**OXFORDSHIRE COUNTY COUNCIL'S RESPONSE TO CONSULTATION ON THE
FOLLOWING DEVELOPMENT PROPOSAL**

Application no: 15/00344/REM

Proposal: 108 dwellings, associated parking and access arrangements, drainage, landscaping and materials

Location: Parcel E Phase 4, Longford Park Road, Bodicote

TITLE			
Longford Park, Banbury Phase 3- Tree Pit Details			
CLIENT			
Barratt Homes Ltd			
SCALE	DATE	DRAWN	CHK'D
Refer to drawing	FEB 2015	BS	AM
DRAWING NUMBER	REVISION		
5205/PH3.TPD1.4

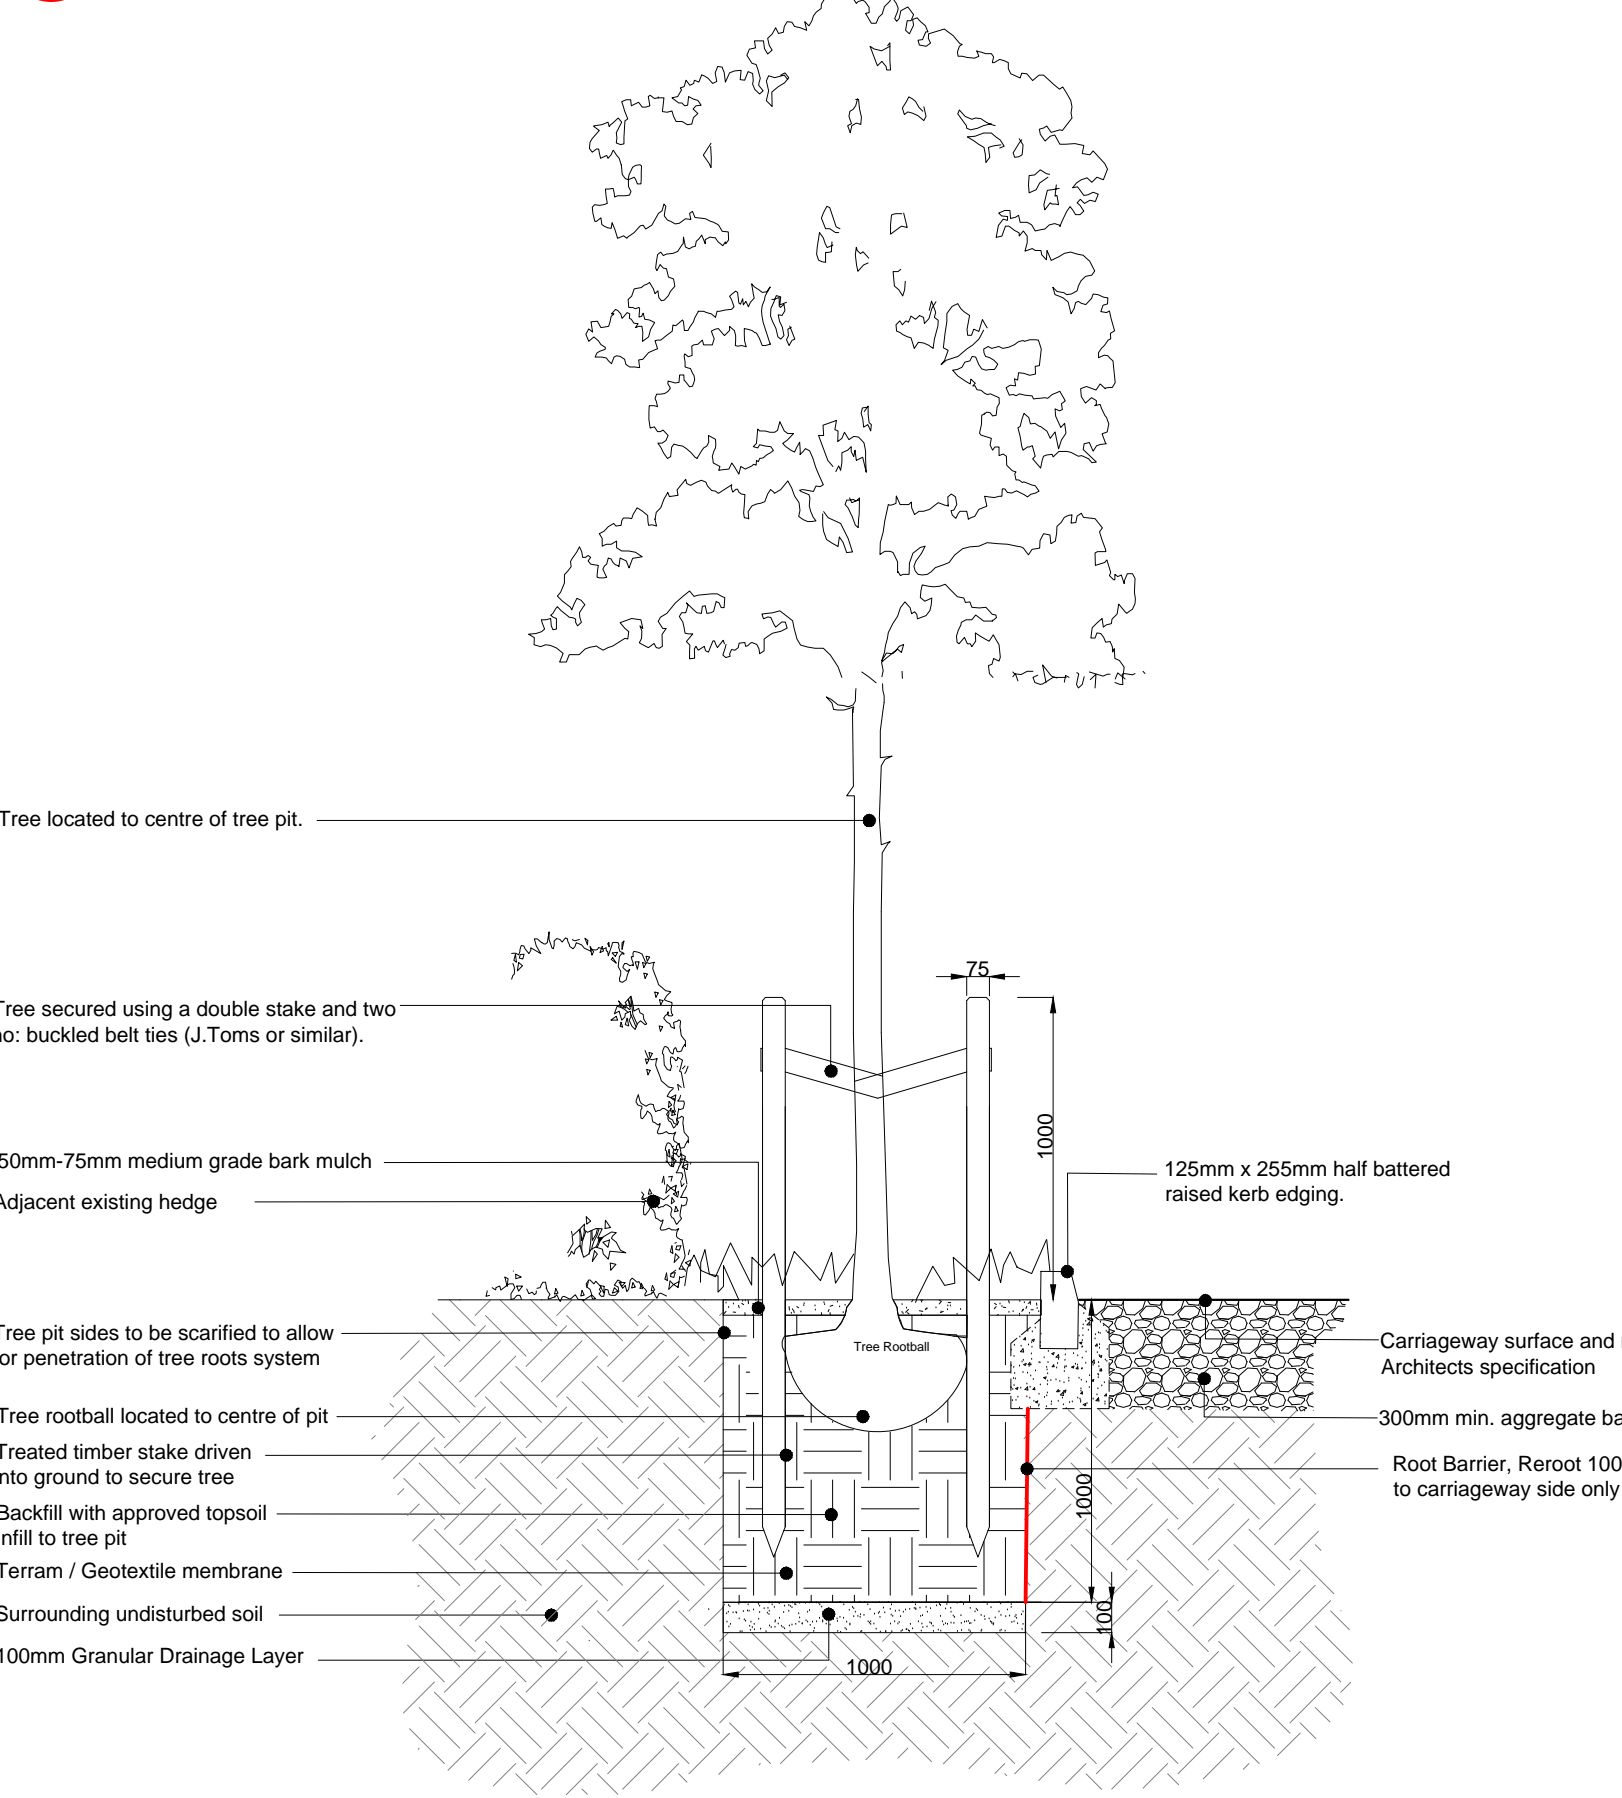
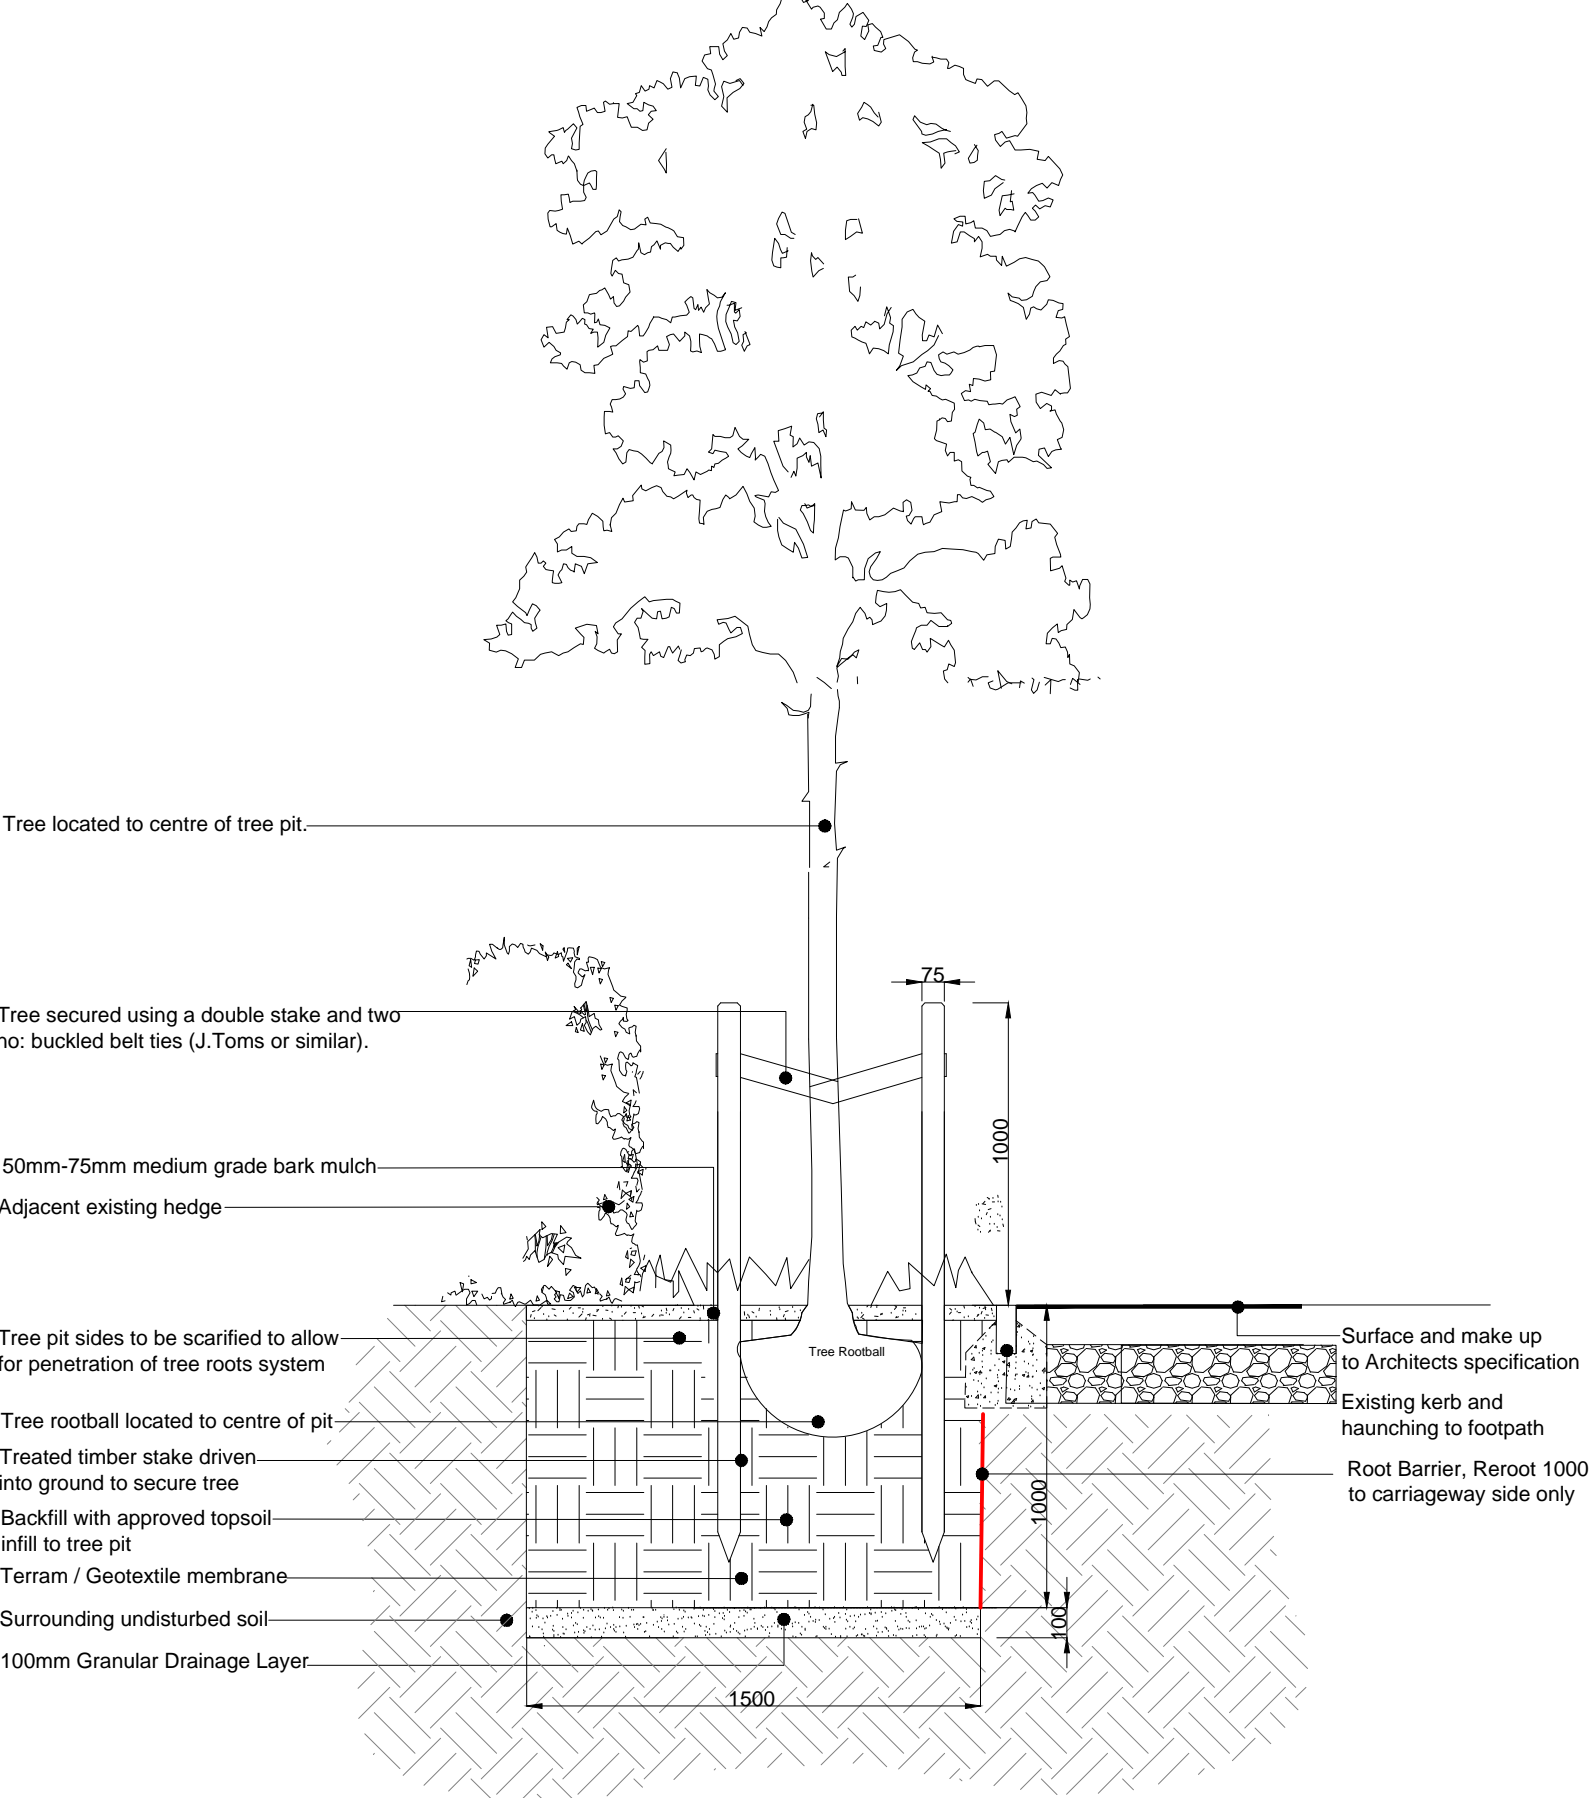
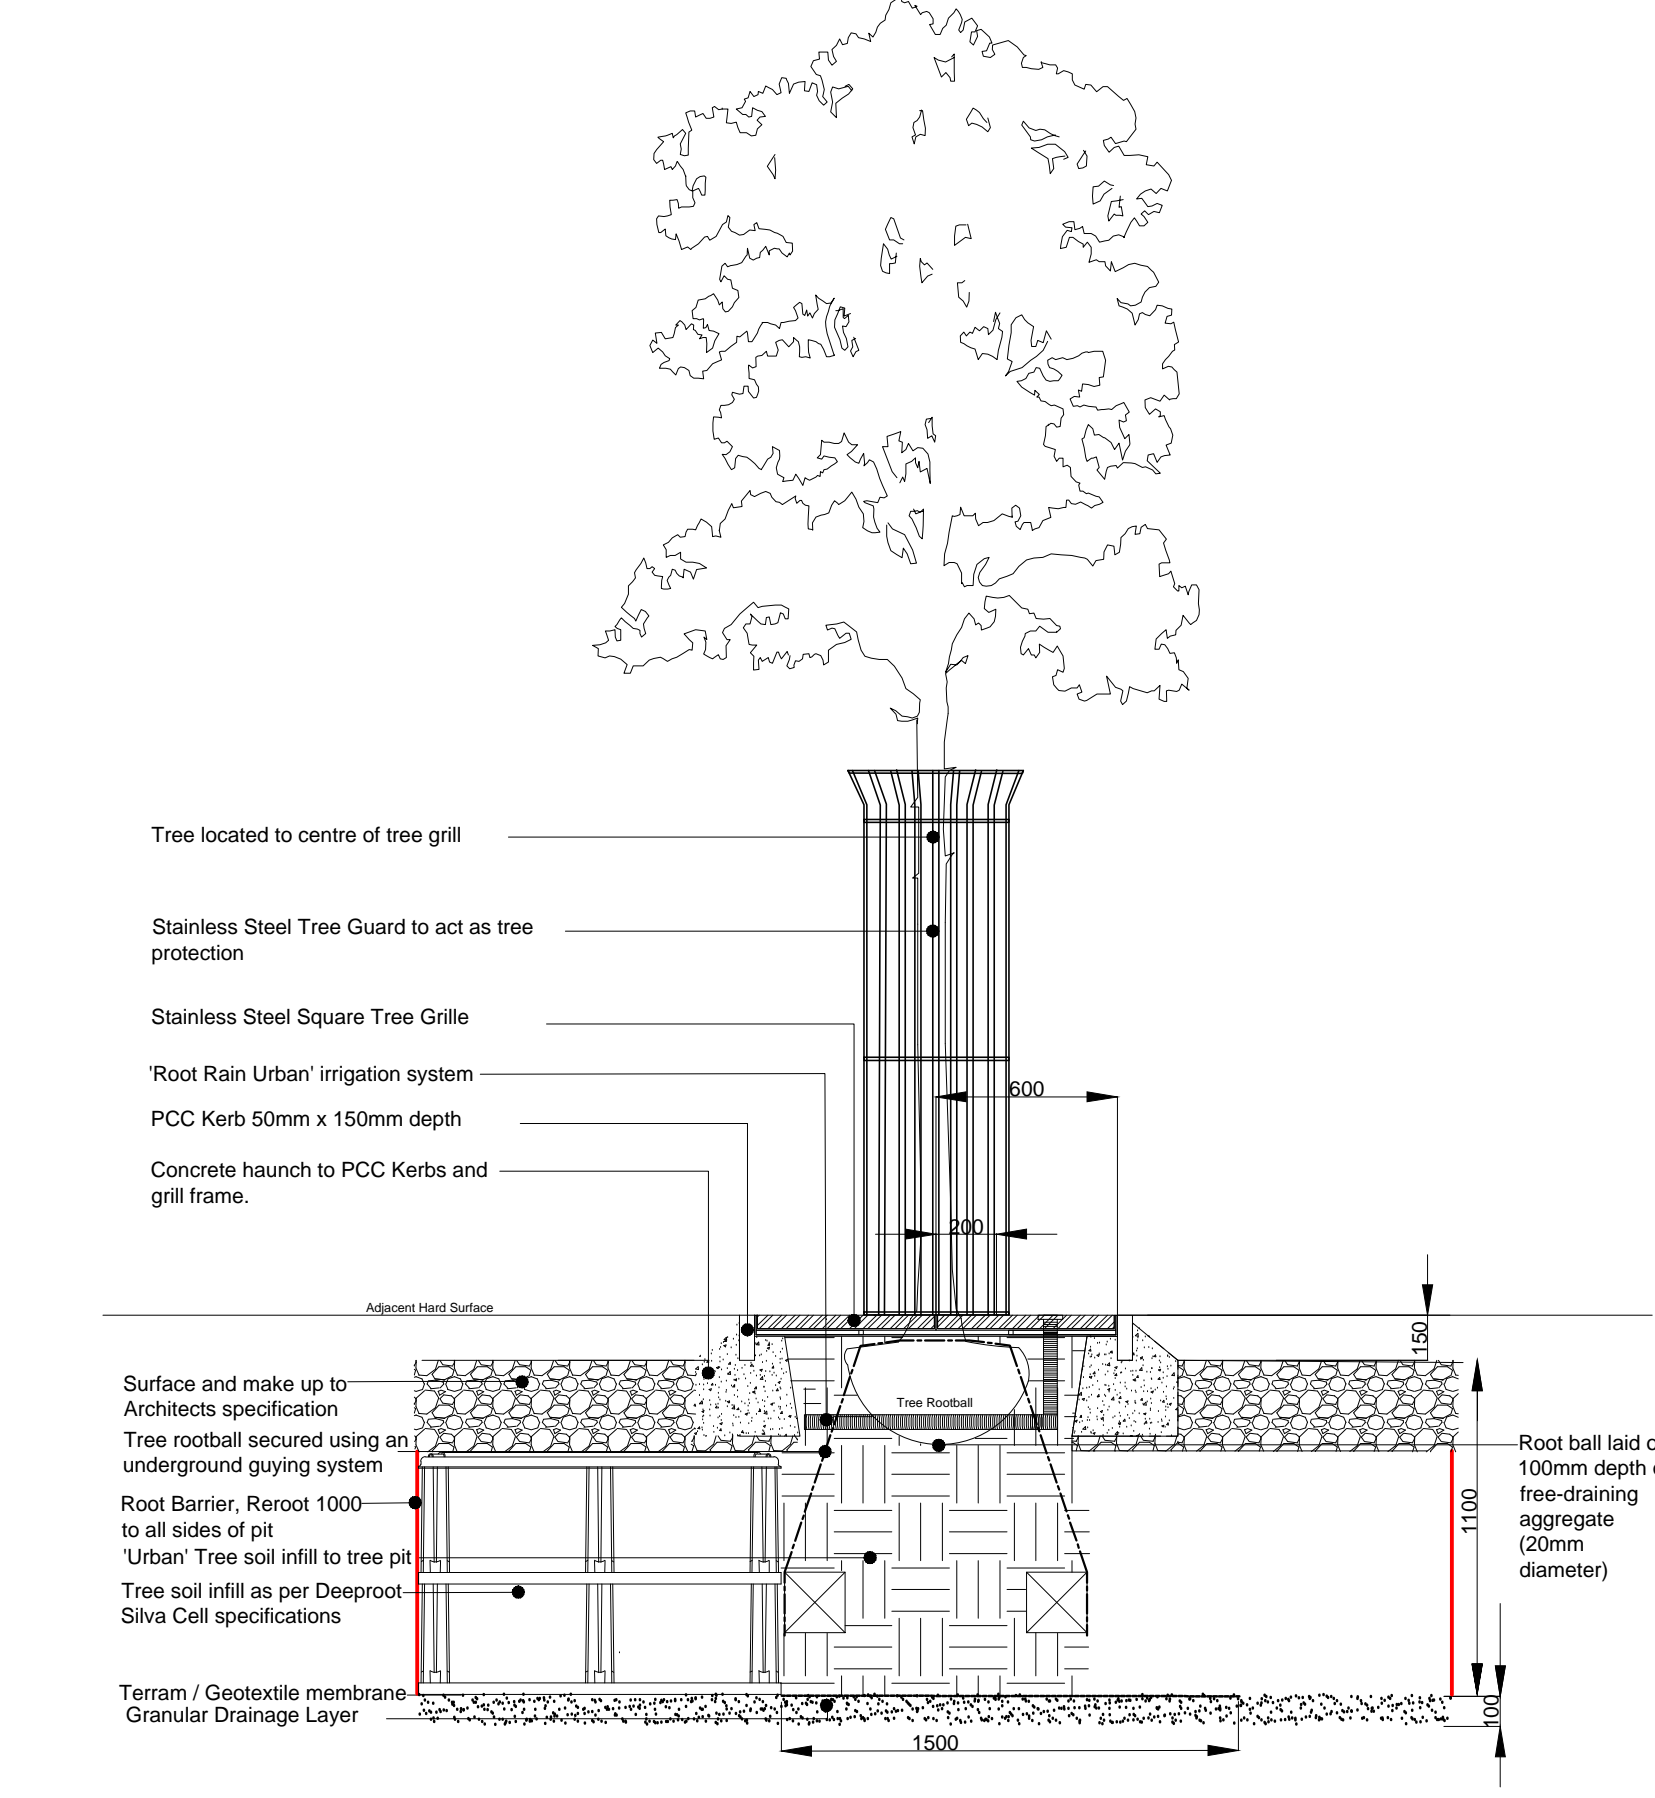
It is noted there are trees indicated on the drawing within the proposed highway on this basis it will be necessary for the applicant/developer to provide a commuted sum with respect to the future maintenance liability at a cost of £1200 per tree.
